TfNSW Reference: SYD24/00274/03
DPHI's Reference: SSD-45576956

**EXHIBITION OF ENVIRONMENTAL IMPACT STATEMENT (EIS)
CHILDREN'S MEDICAL RESEARCH INSTITUTE - GENE TECHNOLOGIES BUILDING
214 HAWKESBURY RD, WESTMEAD**

TAB A - TfNSW advisory comments

Figure 2: Access Arrangement

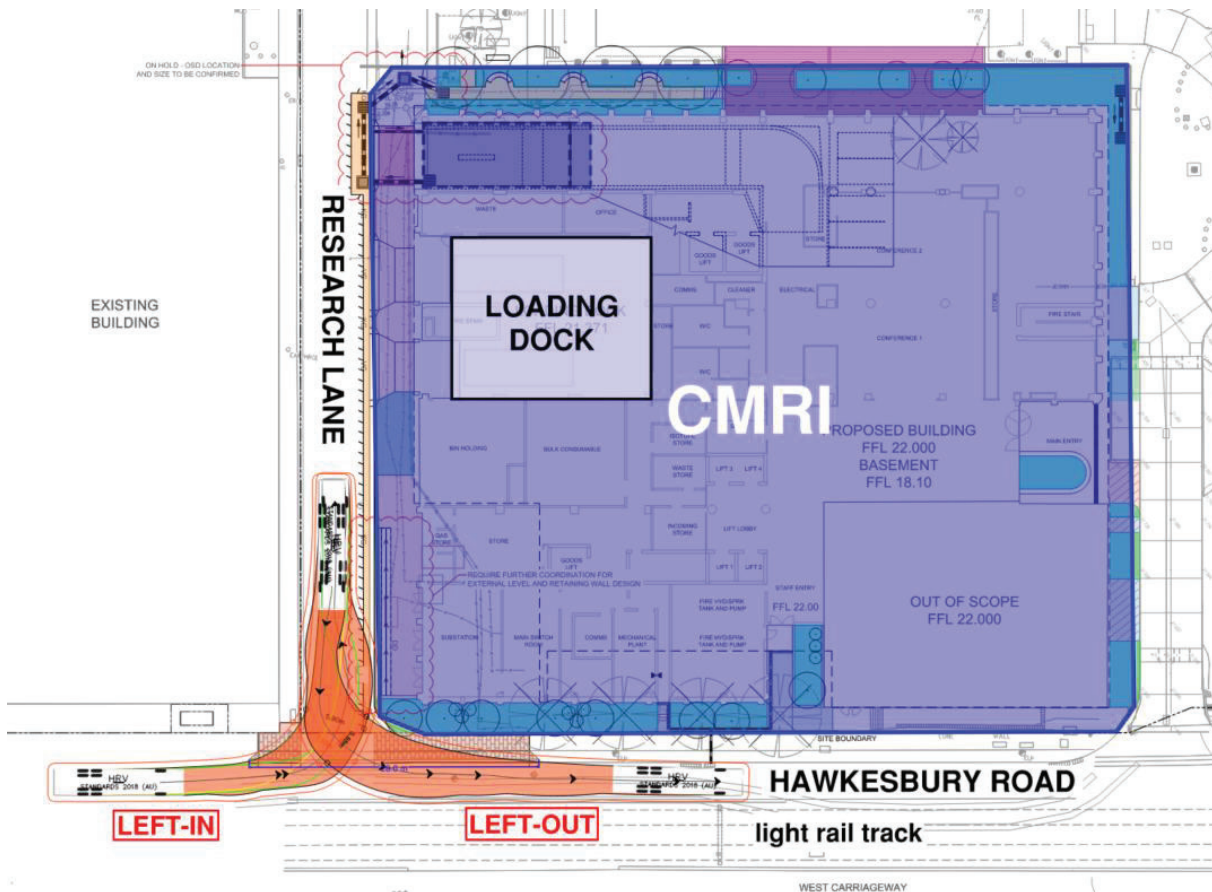
Swept paths for Heavy Rigid Vehicles (**HRV**) are shown to cross the deterrent kerbs for the light rail tracks for both access and egress movements at the intersection of Hawkesbury Road and Research Lane.

TfNSW does not support any scenario in which vehicles encroach onto the light rail tracks. There have been several collisions and near misses at the intersection of Hawkesbury Road and Research Lane caused by this exact situation (heavy vehicles entering the light rail corridor to access Research Lane). TfNSW is currently in the process of investigating physical measures to restrict such incidents occurring.

Site vehicular access points that require vehicles to pass over a light rail are not supported and are to be avoided. Where this cannot be avoided, significant restrictions can be imposed on the Applicant to demonstrate that vehicle access minimises conflict issues with pedestrians and light rail vehicles.

TfNSW recommends restricting the size of servicing vehicles or utilising alternate routes such as Redbank Road for service vehicle access to avoid ongoing safety and operational impacts to Parramatta Light Rail.
